DECISION DELEGATED TO HEAD OF PLANNING**DECISION DELEGATED TO HEAD OF PLANNING**

Application No: H04-0184-24 **Applicant:** AGR Solar 2 Ltd

Proposal: Details of Landscape & Ecological Management Plan (Condition 19 and also relating to Conditions 17, 18 & 20 of H04-0849-22)

Location: Land To The West Of Cowbridge Road Bicker Fen Boston

Appendix 1: Landscape Masterplan

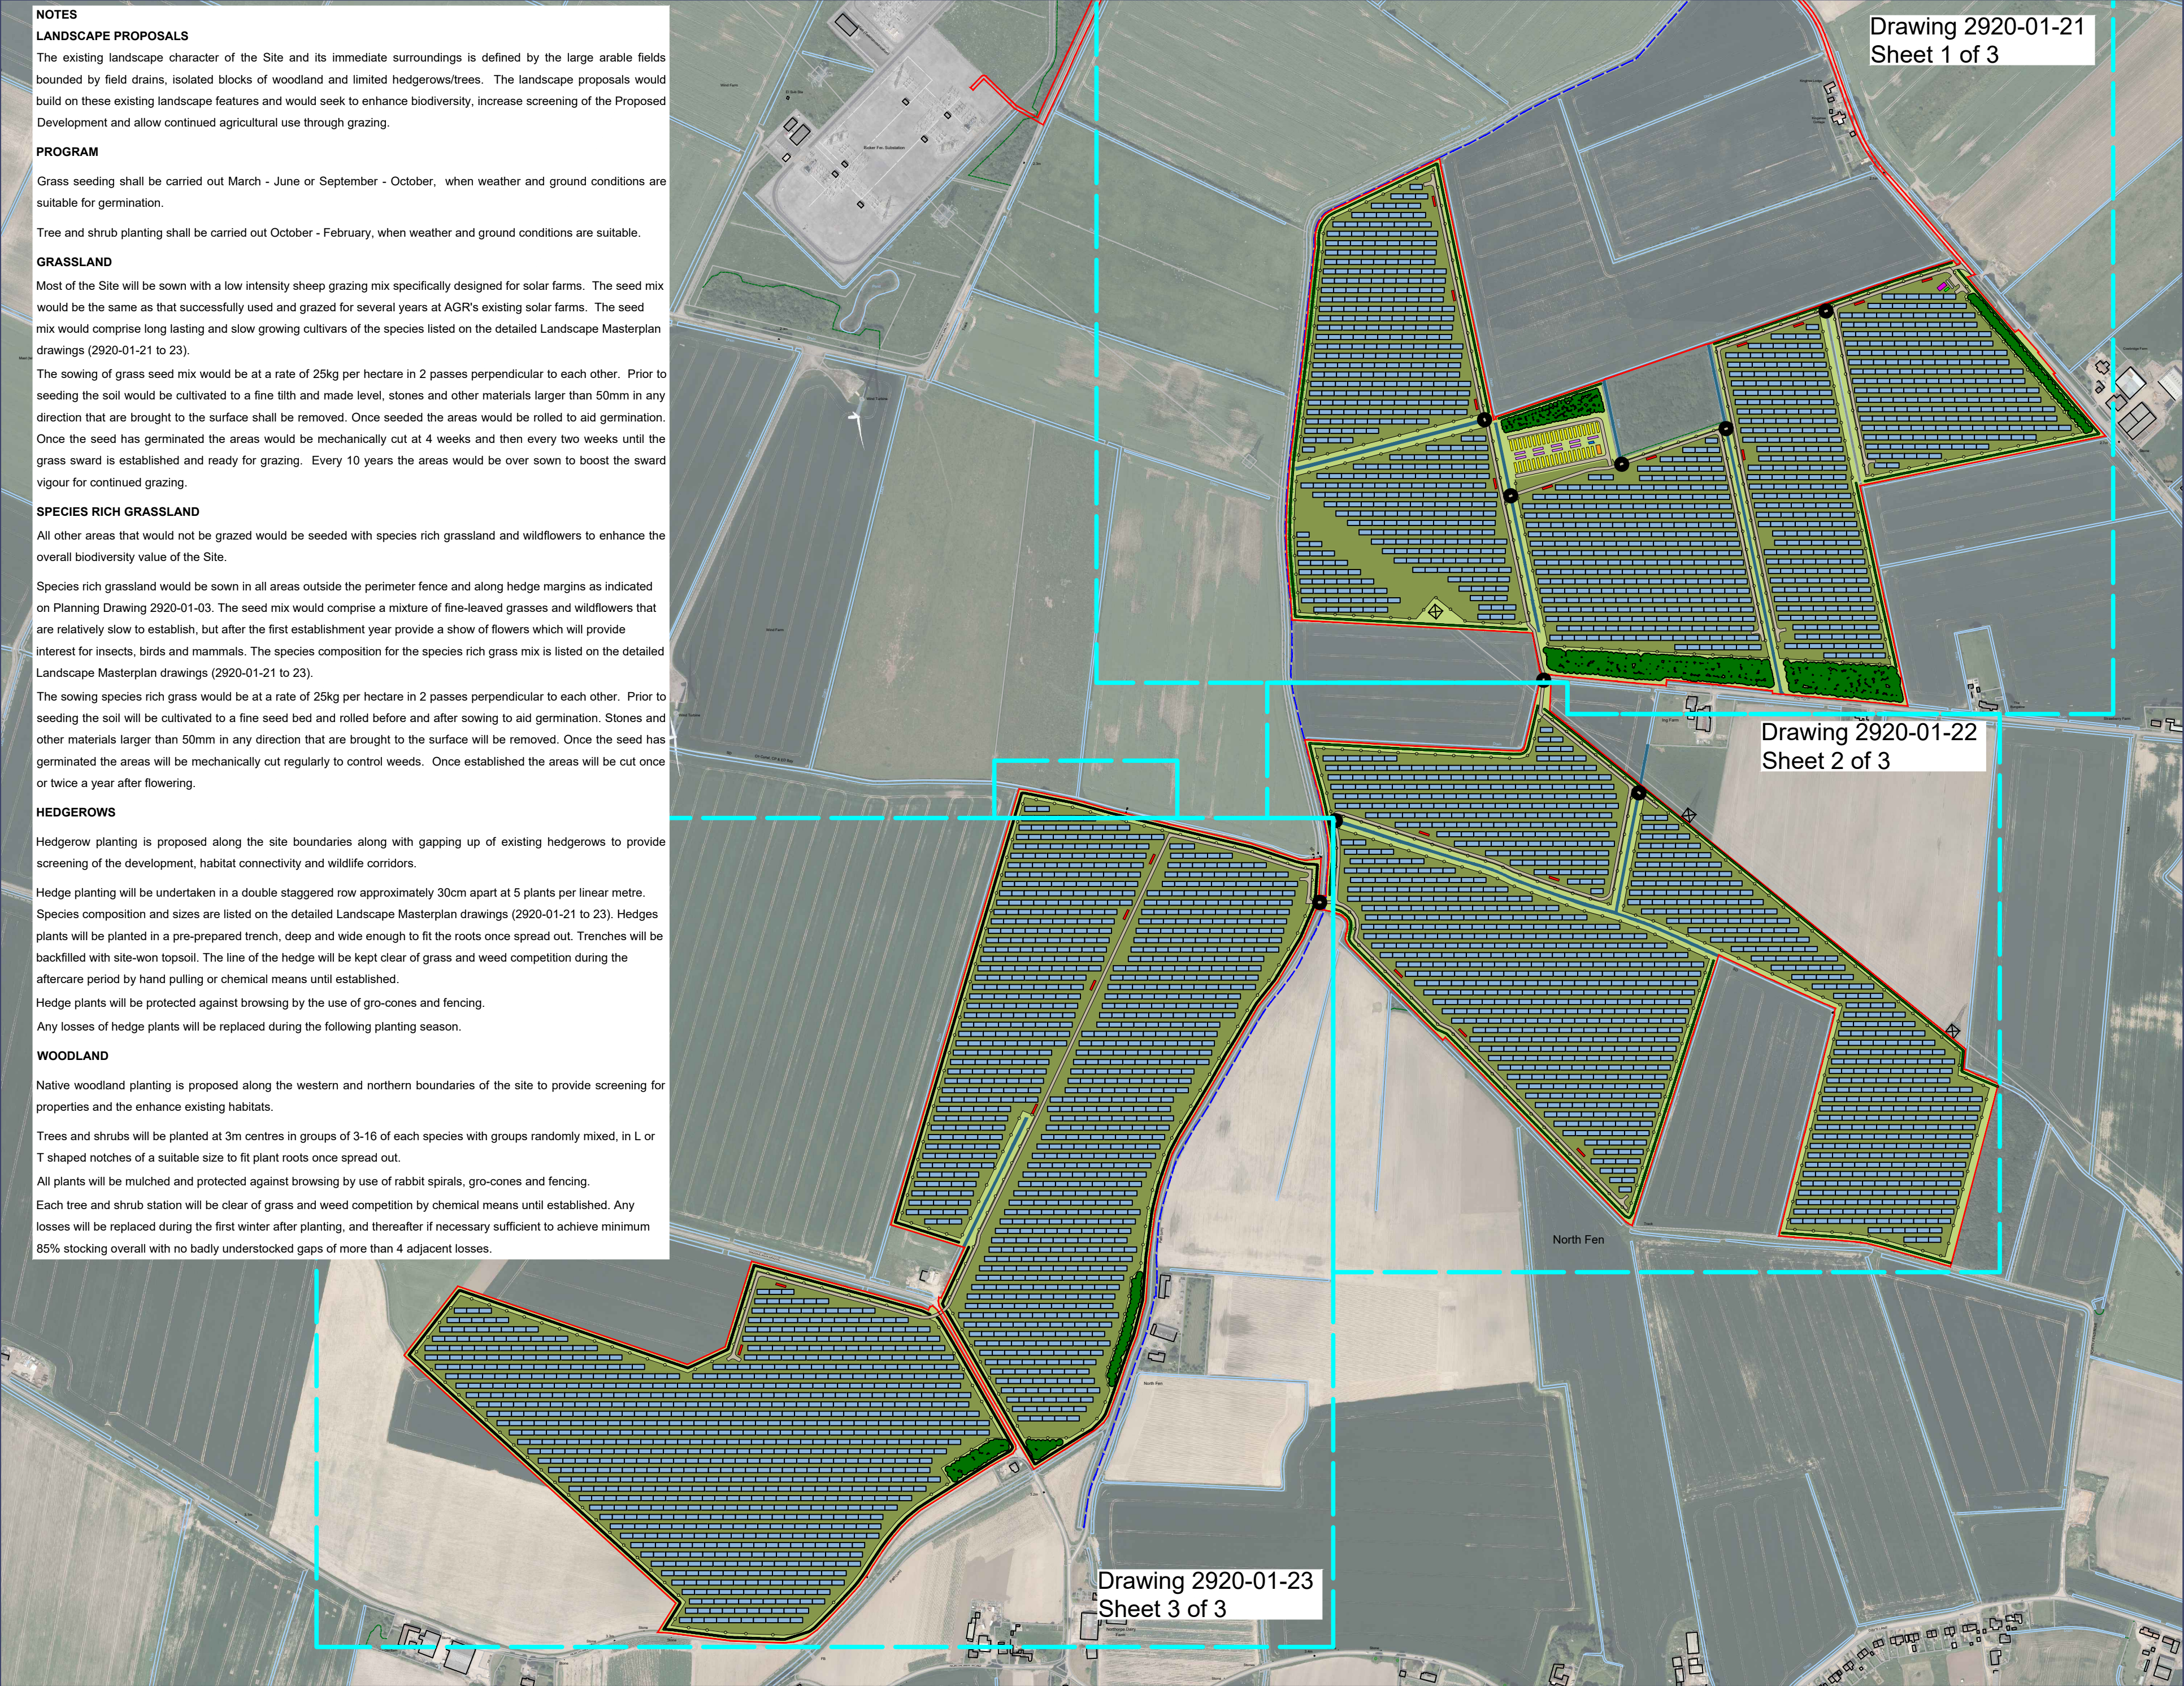
It would appear from the plans provided that the applicant intends to plant hedgerows within 9 metres of IDB-maintained watercourses. The applicant is advised that this will not be acceptable to the Board, and as such the Board OBJECTS to this application.

However, the Black Sluice IDB objects to the proposals due to hedgerows being planted within 9m of an IDB. The Board requires these 9m strips to be kept clear of obstructions to carry out annual maintenance and improvement works by machinery throughout the year. The plans include planting hedgerows within 9 metres of IDB maintained watercourses, which is not acceptable to the Board.

The details conflict with IDB requirements to maintain 9m maintenance strips adjacent to IDB maintained drains, which are required to be kept free of obstructions at all times for maintenance purposes. Without keeping drains free of obstructions, the Board would be unable to maintain the drain, thereby increasing the chances of flooding. The proposals are not therefore acceptable therefore the condition cannot be discharged.

With an objection such as this, this means the proposals are likely to affect flood risk, and as such, without measures to ensure that drains are maintained adequately, this increases the risk of flooding. As such the proposals need to be re-designed so that they conform with IDB requirements.
